# Cabarita Beach Mixed Use Development Modification 6

Cabarita Beach Mixed Use Development Modification 6  
Assessment Report  
State Significant Development Modification Assessment  
(MP 07\_0179 MOD 6)

February 2021

LEVEL 1 FLOOR PLAN

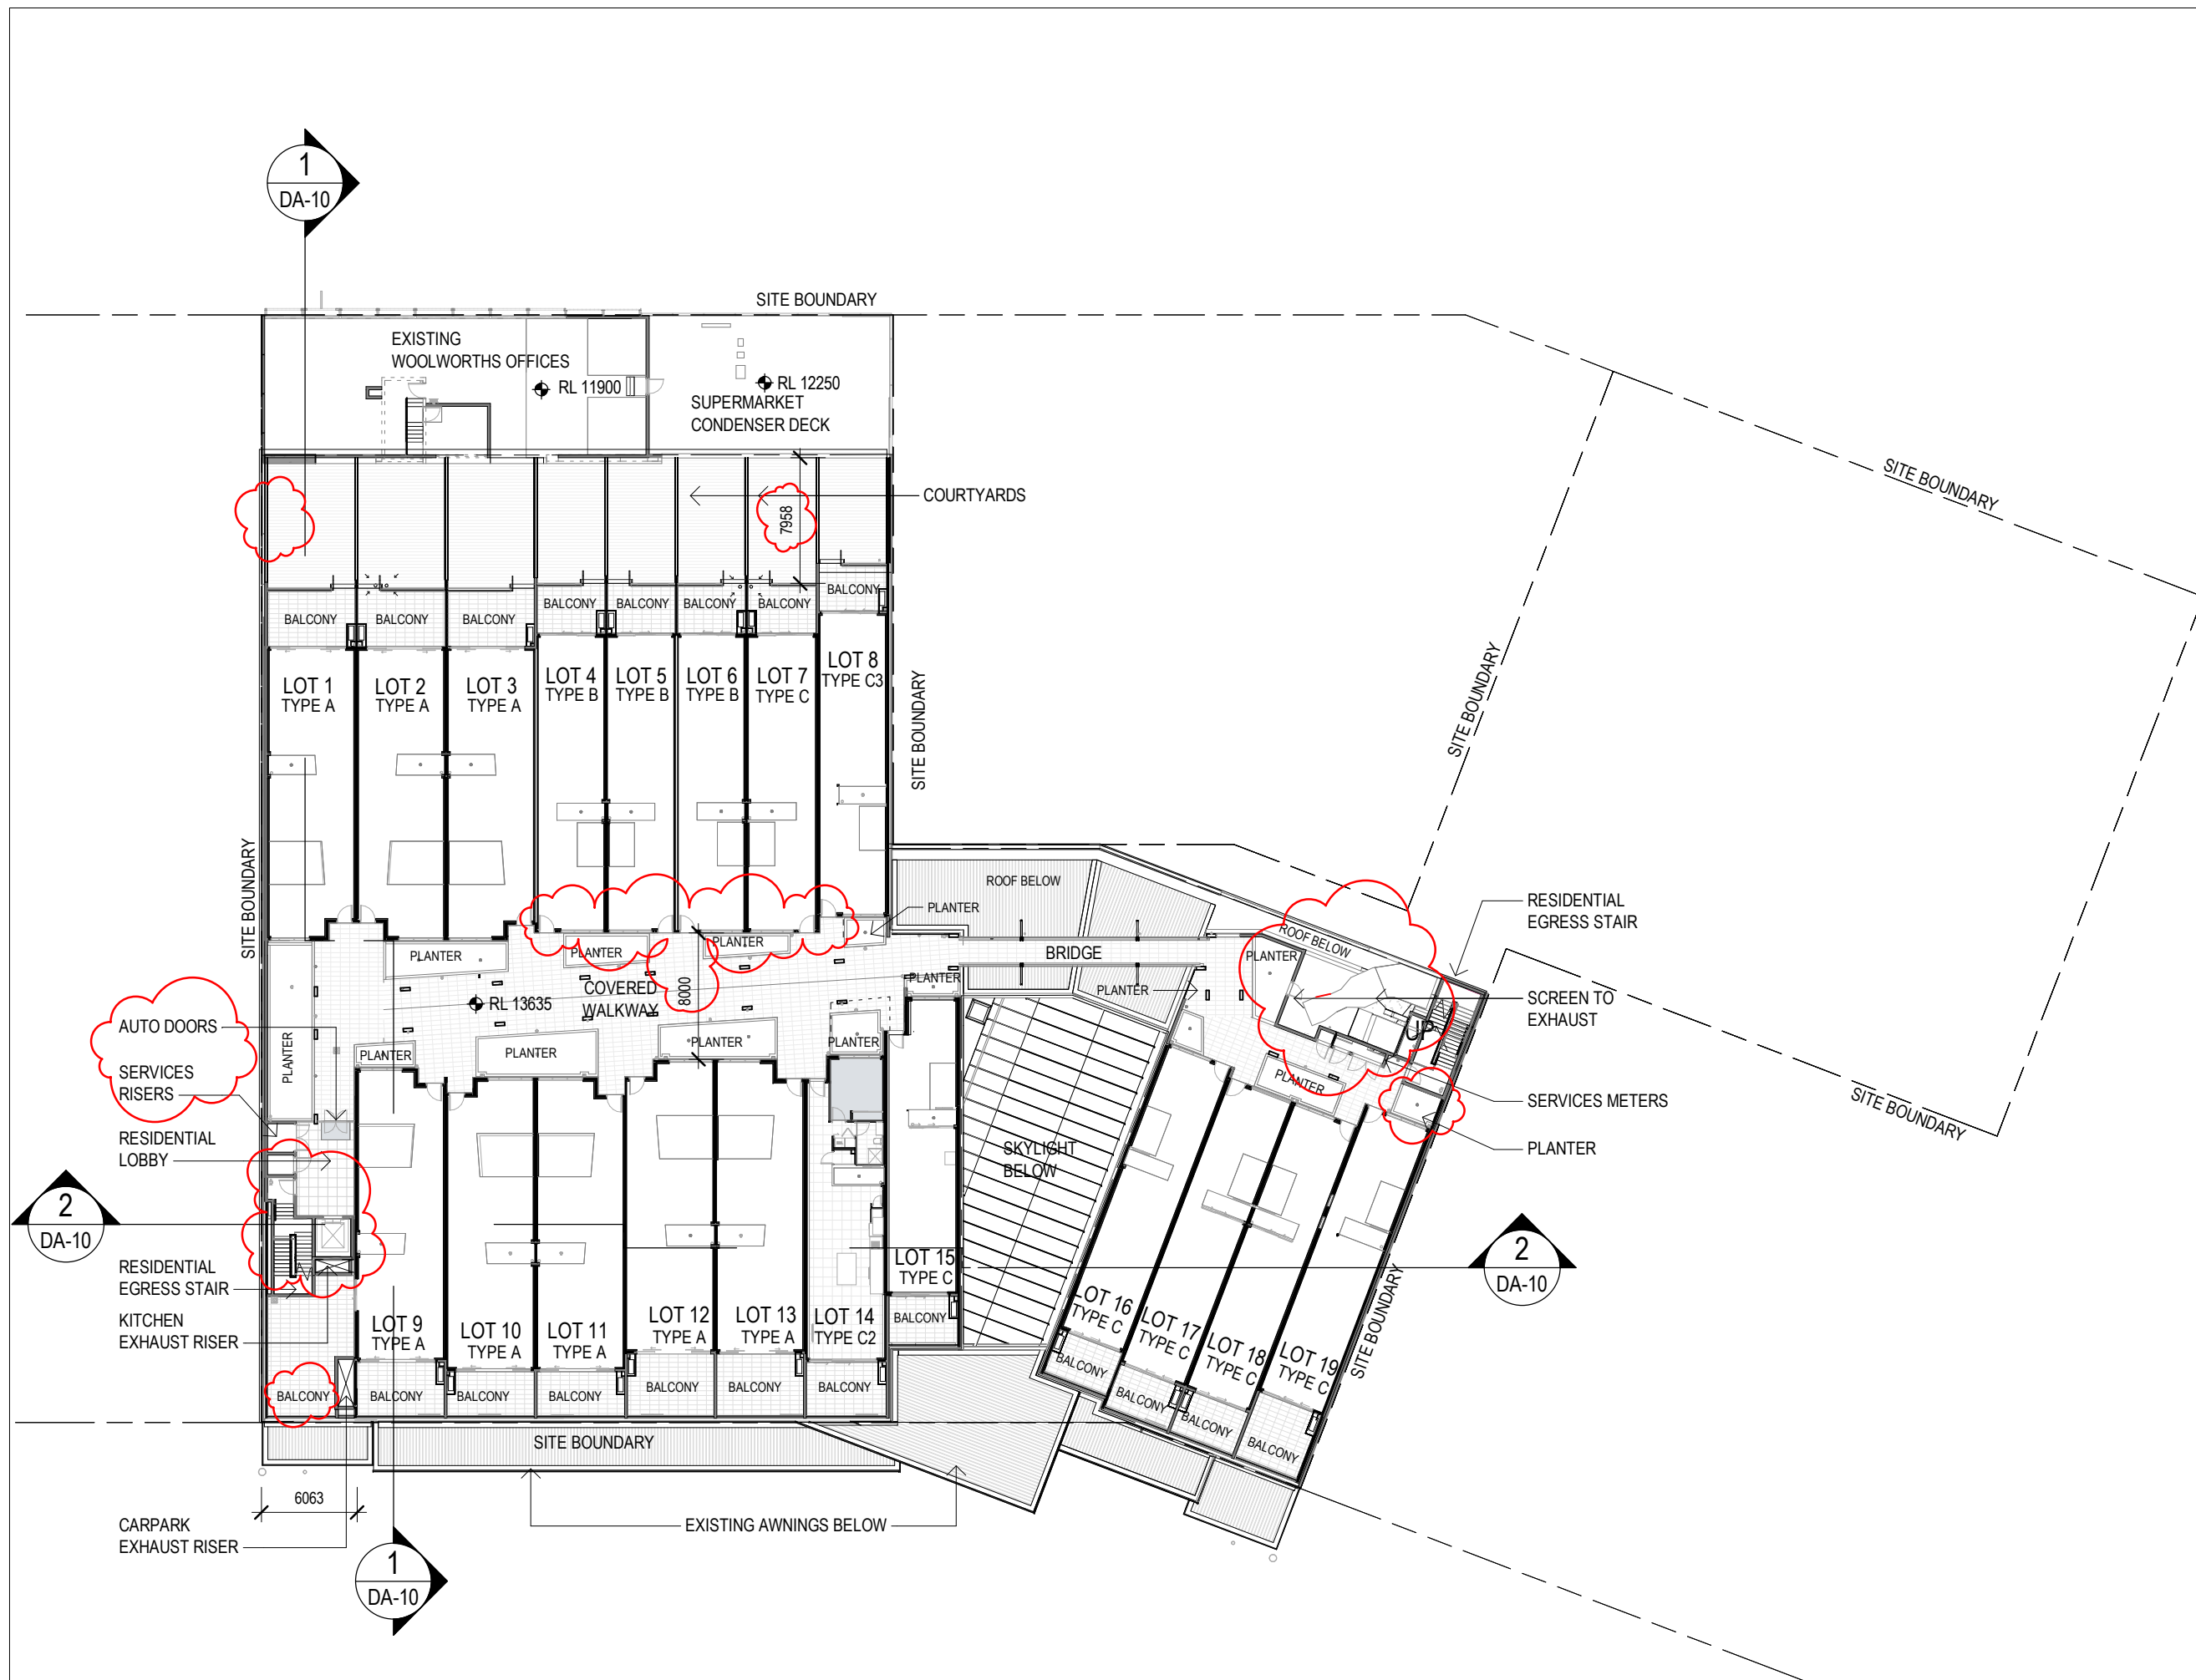
Public and Council submissions raised concerns about the potential impact of the proposed reallocation of landscaped open space to private open space for units 1-8 referred to as 'courtyards' on the properties on Hastings Road. The key concerns are visual amenity, noise and privacy impacts.

Council did not support this reallocation as it represents a missed opportunity for public open space and limited detail was provided in relation to the visual impact of the revised proposal when viewed from street level of Hastings Road. Council noted that it may be more appropriate to allow individual access from units 1-8 as proposed, but to retain the area as a single landscaped area which allows for access for other unit occupiers.

The Applicant has provided additional plans detailing sightlines from the neighbouring properties on Hastings Road. The plans demonstrate neither the courtyards nor the units are visible from the opposing properties. As the courtyards are not visible from surrounding properties, the Department is satisfied that utilising this area as a landscape buffer for visual amenity purposes is of minimal advantage, as it would provide no benefit to adjoining properties. Similarly, landscaping this podium will provide no benefit to privacy as there are no significant impacts in this regard.

The Department is satisfied that this proposed reallocation of space is appropriate in this case, as the space is not being used to provide any benefits to surrounding properties and will not cause

significant noise, privacy or visual amenity impacts as the space is not visible from adjoining properties.

ROOF PLAN

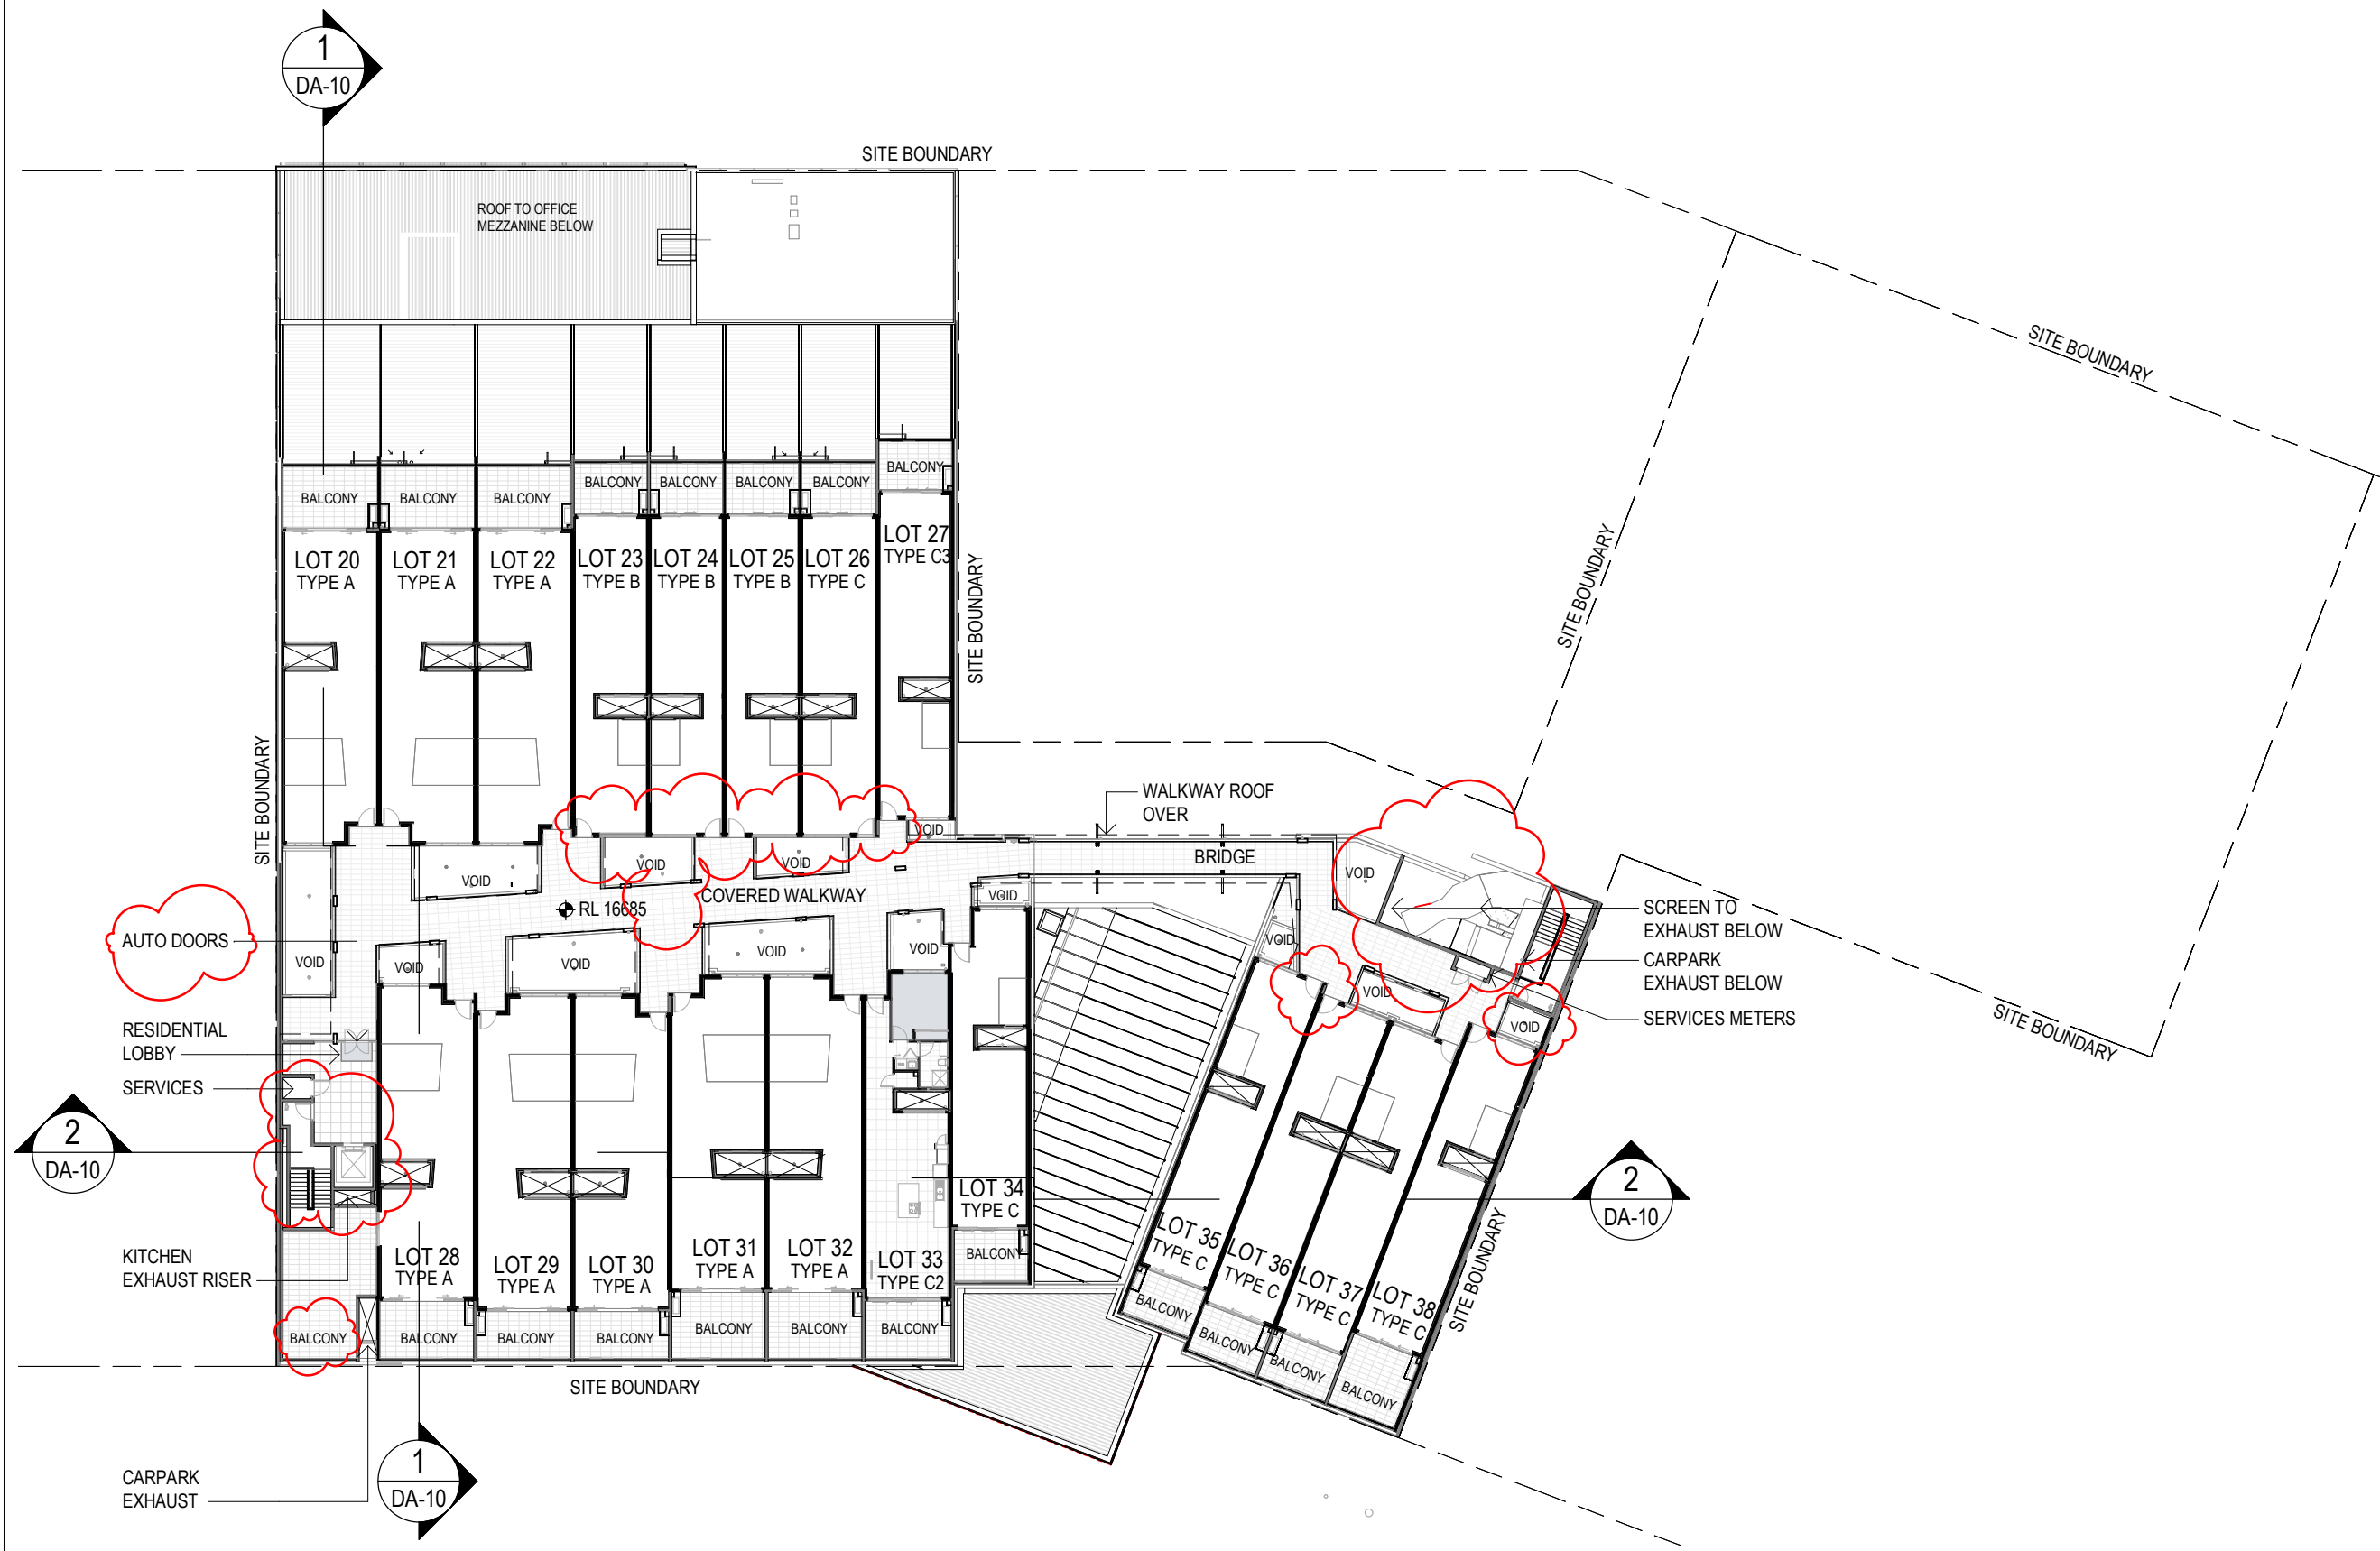
<b>Roof Profile</b>	Council commented on the proposed alteration of the roof profile.	No additional conditions or changes to existing conditions are necessary.
	The change in roof profile will not cause additional impacts on visual amenity or exceed maximum building heights. The roof level is proposed to increase in some locations, however remains under the approved maximum height along Tweed Coast Road and Hastings Road.	
	The roof profile to Tweed Coast Road will remain similar to that approved, retaining the inclusion of eaves and remaining articulated.	
	Therefore, the Department is satisfied that the alteration of the roof profile will not create any significant impacts and is consistent with the intent of the original design.	
<b>Condition A1</b>	This condition refers to Stage 2 including 40 upper level residential units. Modification 1 of this development sought approval to reduce the number of units from 40 to 38.	Condition A1 is recommended to be amended to reflect the approved number of units.
